**CONSULTATION UNDER THE TOWN AND COUNTRY PLANNING
(DEVELOPMENT MANAGEMENT PROCEDURE ENGLAND) ORDER 2015**

Applicant:	Reside Developments Ltd
Planning Application Reference:	BN/147/21/OUT
Proposal:	Outline application with all matters reserved (except access) for the erection of up to 8 No. dwellings.
Location:	Land west of Fontwell Avenue Fontwell Avenue Eastergate PO20 3RX
Date:	20 December 2021

Portsmouth Water's Position

Title
OUTLINE DRAINAGE STRATEGY

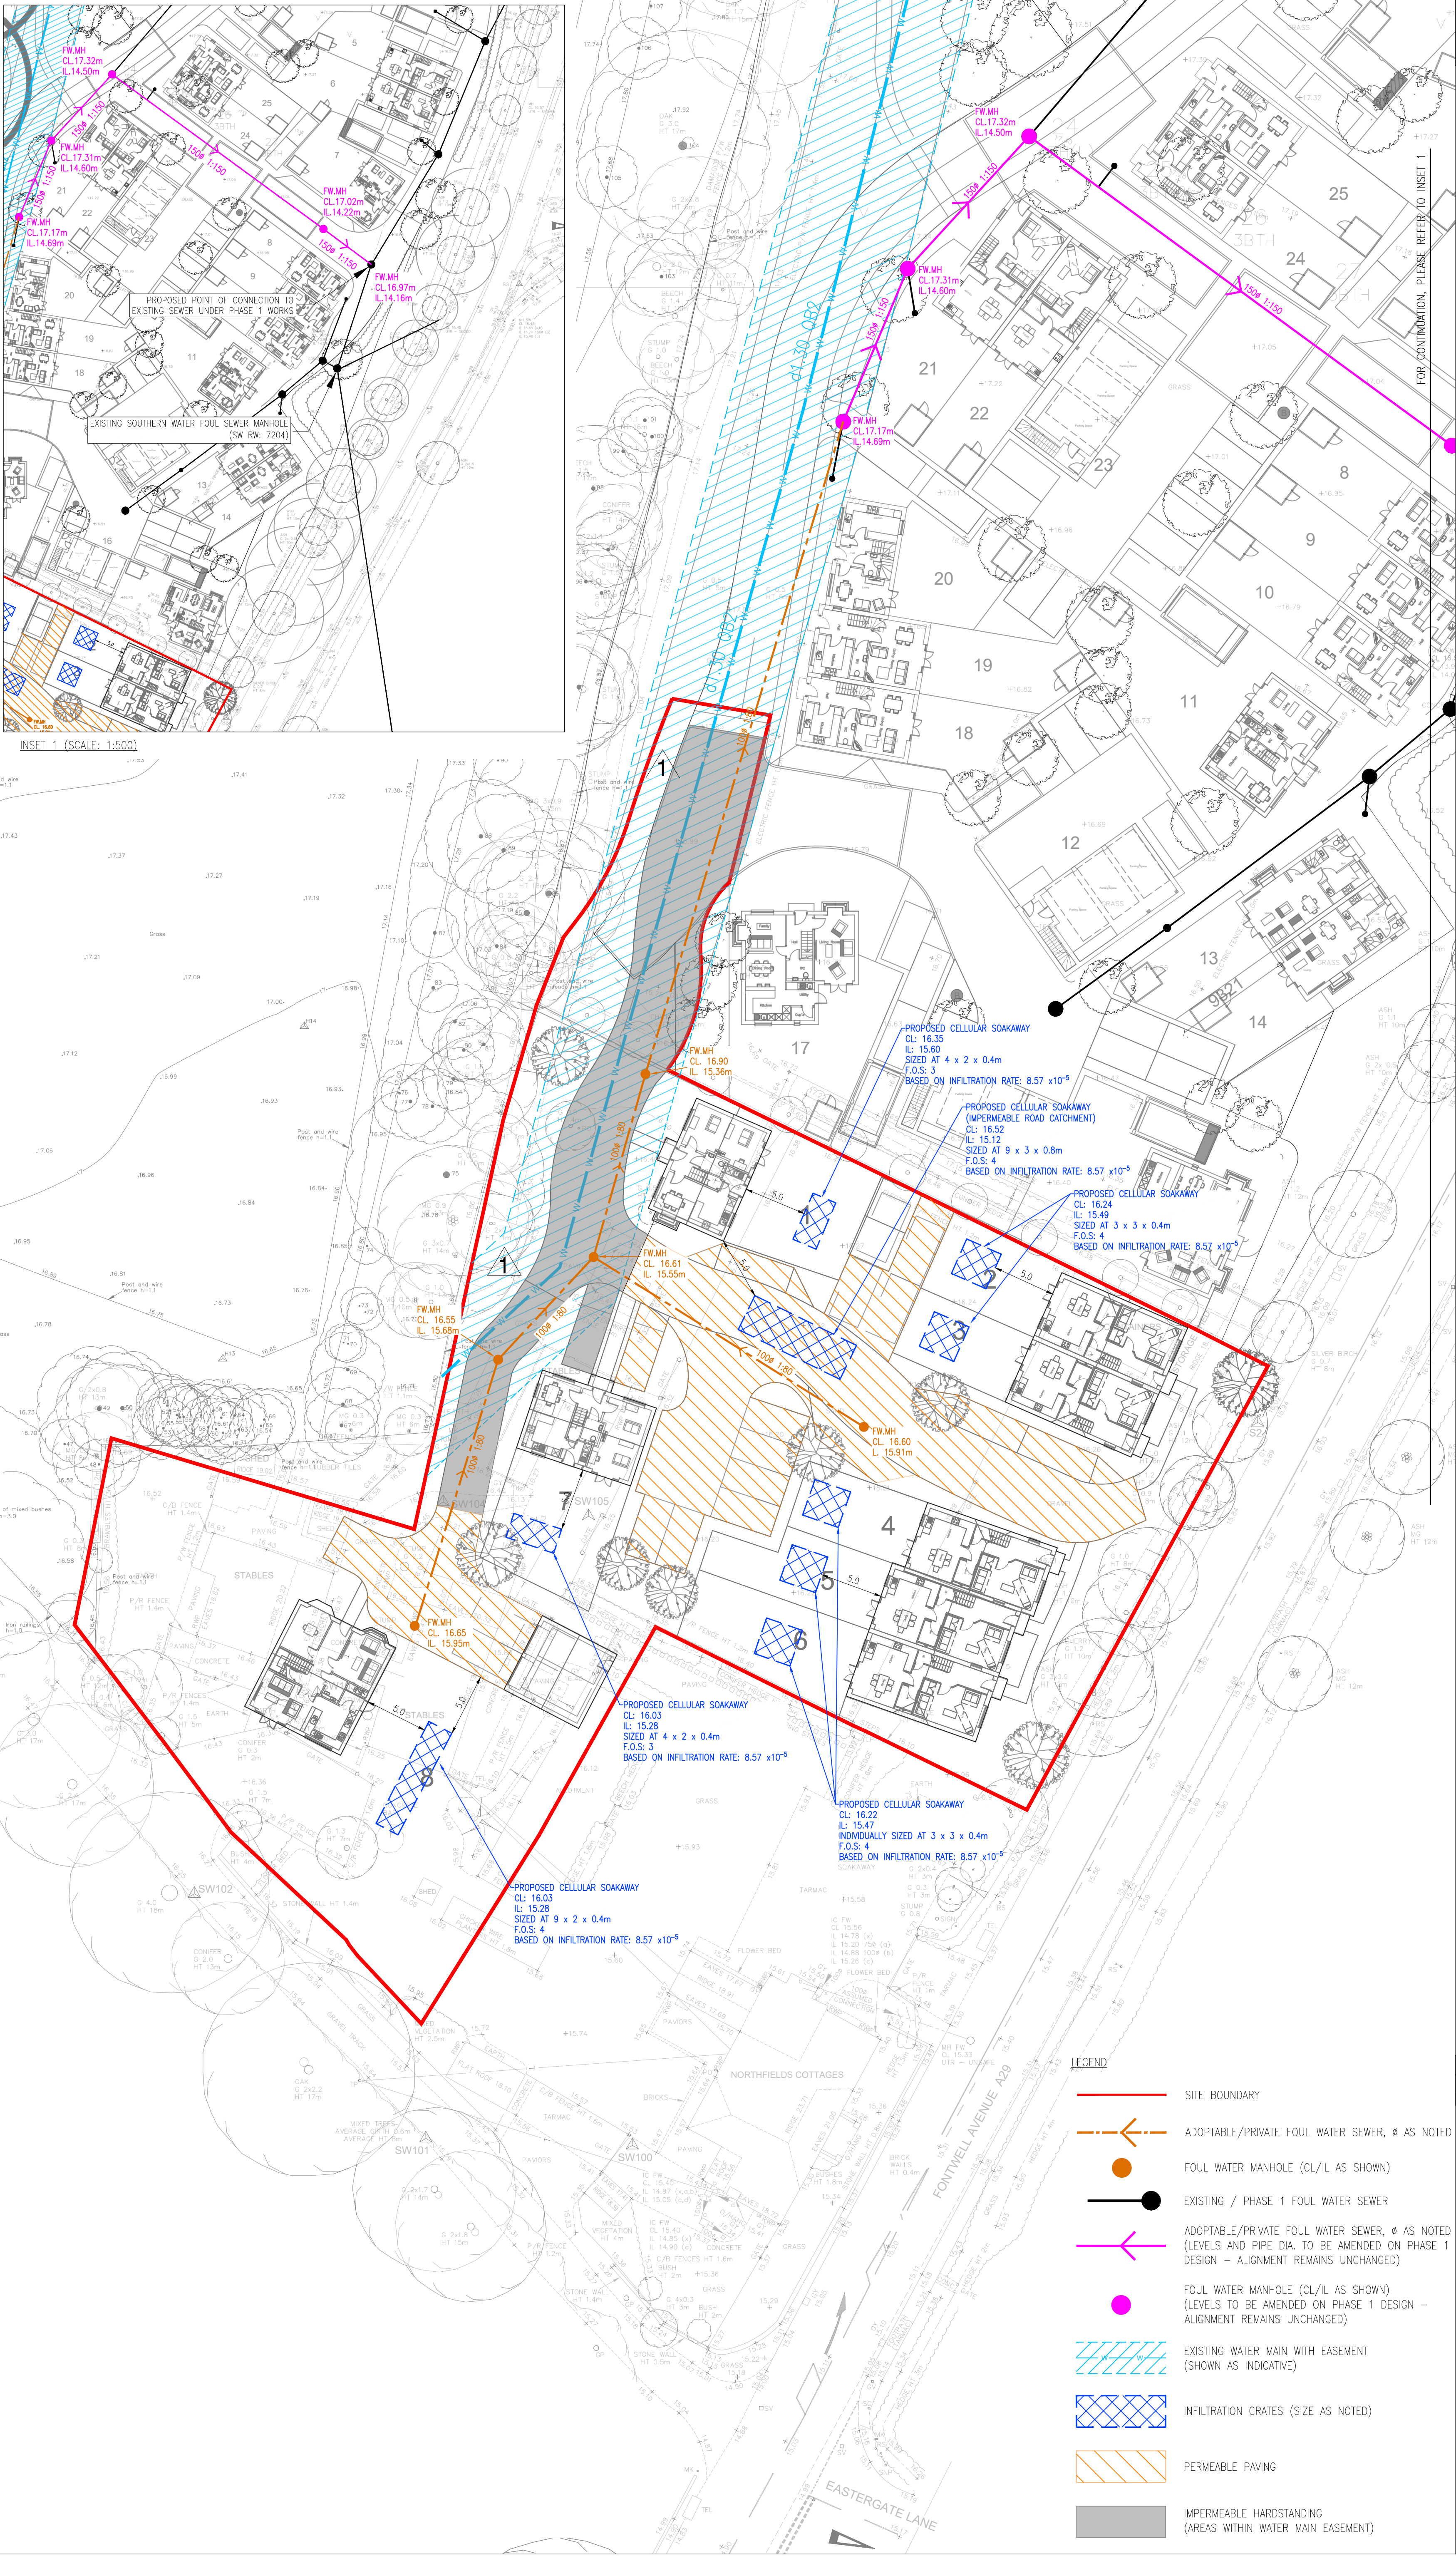
The proposed surface water strategy is disposal via infiltration with a combination of soakaways and permeable pavements. The main roads, parking courts and private drives run off will be managed through permeable pavings. Roof water will be conveyed to cellular crate soakaways. The soakaways are to be shallow in nature and this is acceptable in relation to groundwater protection. If deep bore soakaway(s) are the proposed drainage solution, the application for the construction and installation should be accompanied by an adequate risk assessment demonstrating how the risk to groundwater would be mitigated in the proposed design.

The proposed foul water strategy is discharge into the exiting foul main sewers; this is acceptable to Portsmouth Water in relation to groundwater protection. Portsmouth Water require the use of the highest specification pipework and designs for schemes involving new sewerage systems in SPZ1 to minimise leakage.

We wish to be consulted if there are any deviations from these proposals.
